Re: Objection to SSD-70066710 – Hudson Vine Mixed Use Redevelopment

Thank you for the opportunity to comment on the proposed Hudson Vine Mixed Use Redevelopment (SSD-70066710).

Figure 10 Short Section A (with additional notes in orange)

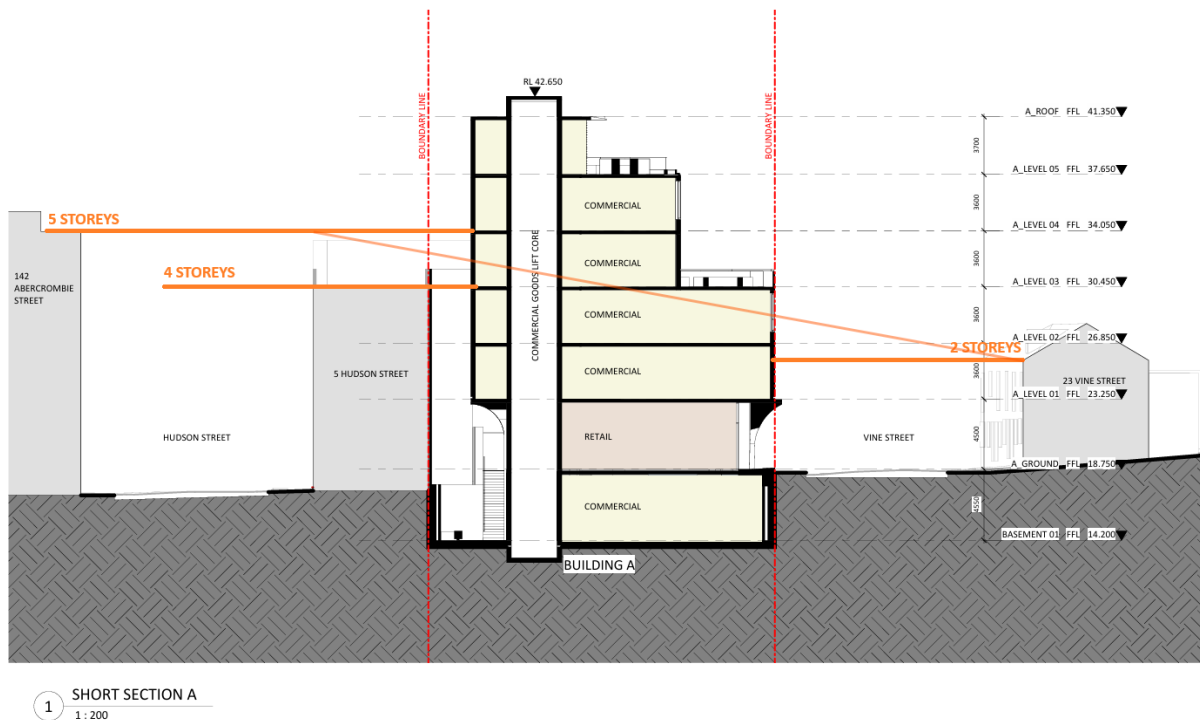
In contrast, the height of the proposed building contradicts the aims of height controls. This can be seen in Short Section A:⁴³

Additional notes have been added in orange, highlighting:

- 2 storeys of the proposed building already exceed the height of the 2 storey terraces at 23 Vine Street
- 3 storeys of the proposed building match the height of the 4-storey mixed use building at 5 Hudson Street
- 4 storeys of the proposed building match the height of the 5-storey residential building at 142 Abercrombie Street
- A building with a responsive design should follow the diagonal line from 5 storeys to 2 storeys

Considering the scale of the surrounding buildings, the proposed building matches the size of a 7-storey development. In contrast to the ADG height controls example, the proposed building exceeds the height of the immediately adjacent building (5 Hudson St), plus both buildings on the other sides of the road (23 Vine Street and 142 Abercrombie Street). Due to most of the surrounding buildings falling within the Darlington Heritage Conservation Area, it is unlikely that their height will change.

- Scale the building to conform with height controls (5-storey on Hudson St; 3-storey on Vine St).
- Increase upper-level setbacks to minimise overshadowing.
- Remove or obscure windows and balconies that compromise neighbouring privacy.
- Conduct a complete visual impact analysis from key street-level perspectives.
- Revise the Clause 16A variation request to reflect site-specific constraints rather than generalised benefits.
- Consider compliant alternatives using adjusted floor-to-ceiling heights or reconfigured layouts.
- Respect heritage values and integrate better with the Darlington Conservation Area.

Figure 14 West Elevation with proposed building windows

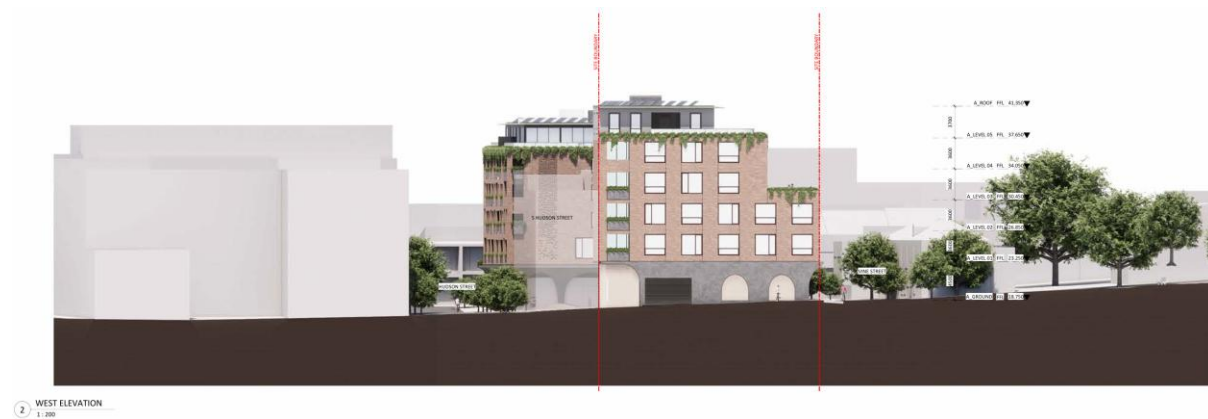
- **Direct Overlooking:** The placement of balconies and windows enables views into private open spaces and bedrooms of neighbouring properties.

- **Insufficient Mitigation Measures:** No evidence is provided of meaningful design responses (e.g., screens, setbacks, vegetation).
